From: Ford, Sarah (PRINCIPAL RIGHTS OF WAY OFFICER)
To: [REDACTED]
Subject: 2021/1089 & 1090, S106 PROW MU1 response
Date: 20 May 2024 08:56:12
Attachments: [image001.jpg](#)

PROW response following letters and meeting.

## 3.5.2 PROPOSED PROW NETWORK

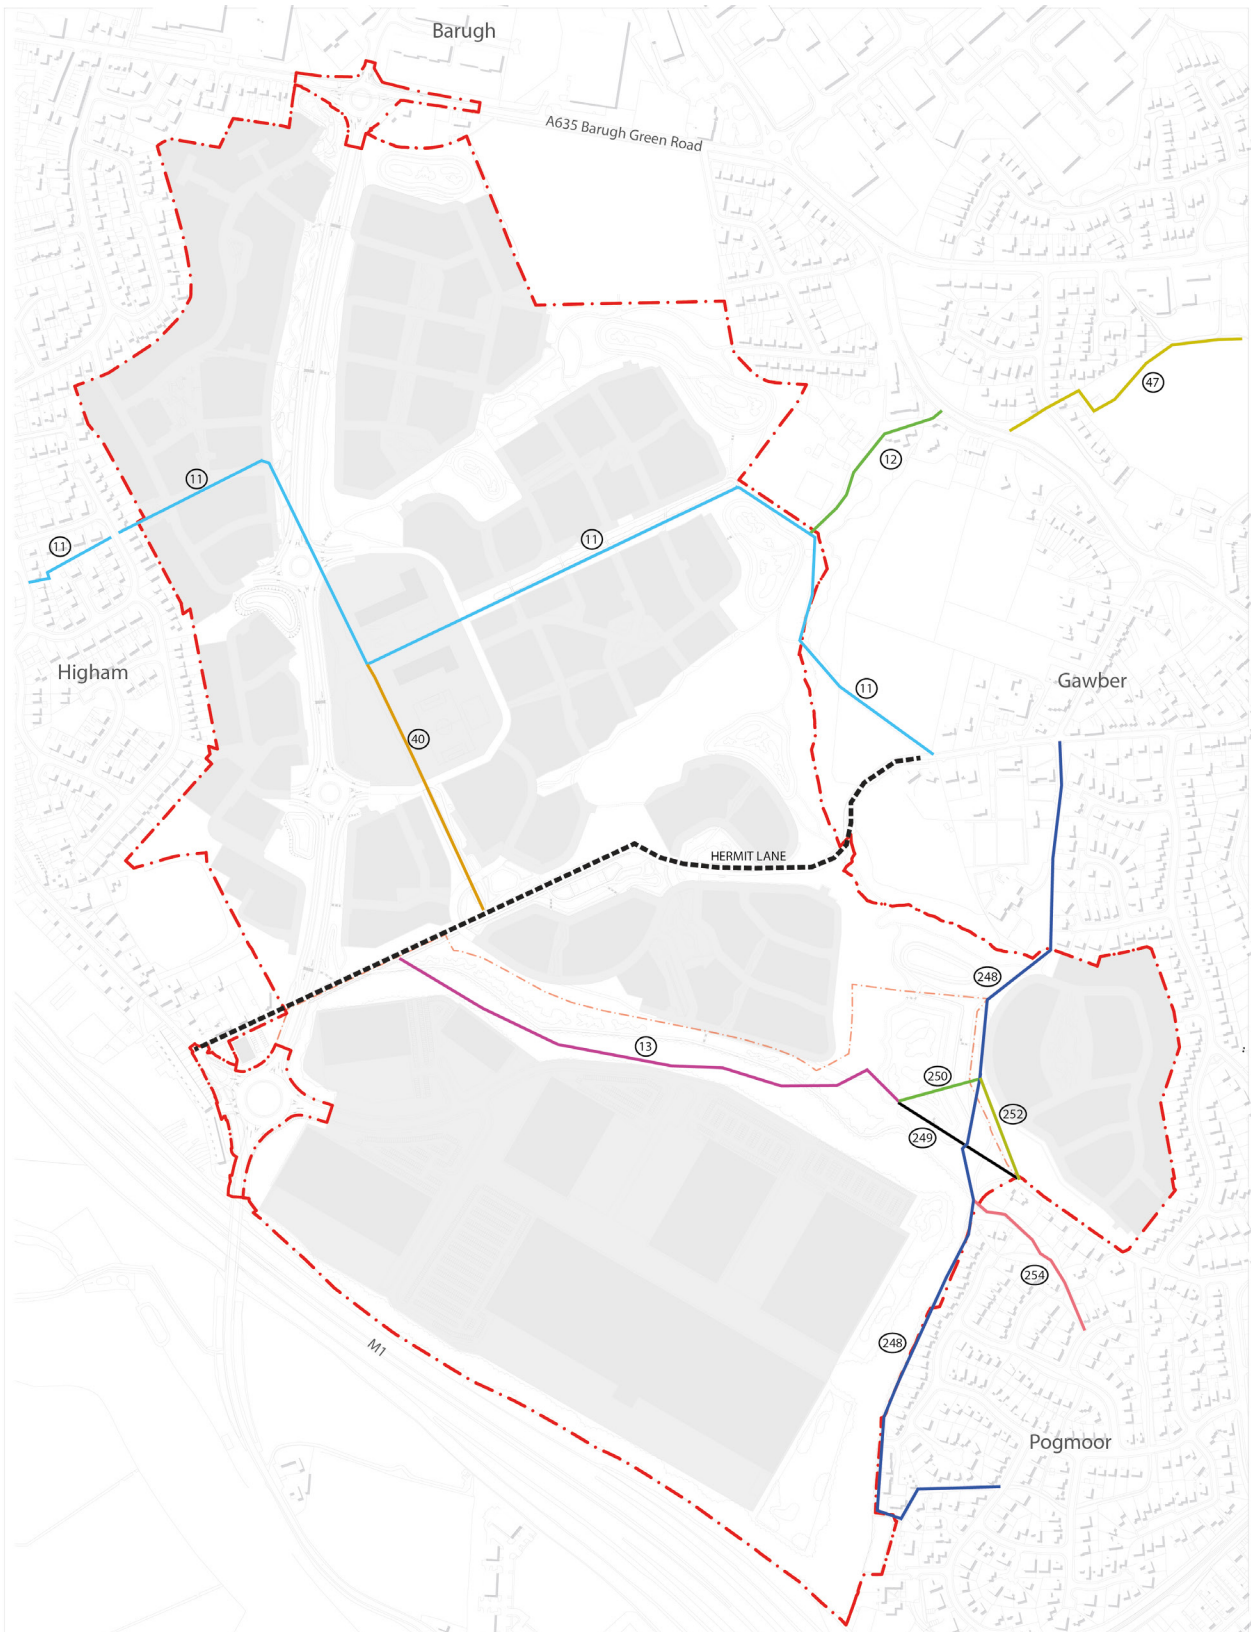
The amended PROW related maps are acceptable, although it is disappointing that the developers do not feel they can agree to additional brideways around the rest of site. I suspect if horseriders are wanting to use additional routes then they will so. If the footway alongside the link road is not specifically designated for pedestrians/cyclists only then it is part of the wider adopted highway which allows horseriders access, likewise they will be able to use any adopted estate road.

Hermit Lane is acceptable as a brideway once vehicle rights have been legally and physically prevented although there are concerns about the closure of the brideway for several years whilst the nearby housing phases are carried out. We will seek to minimise this going forward.
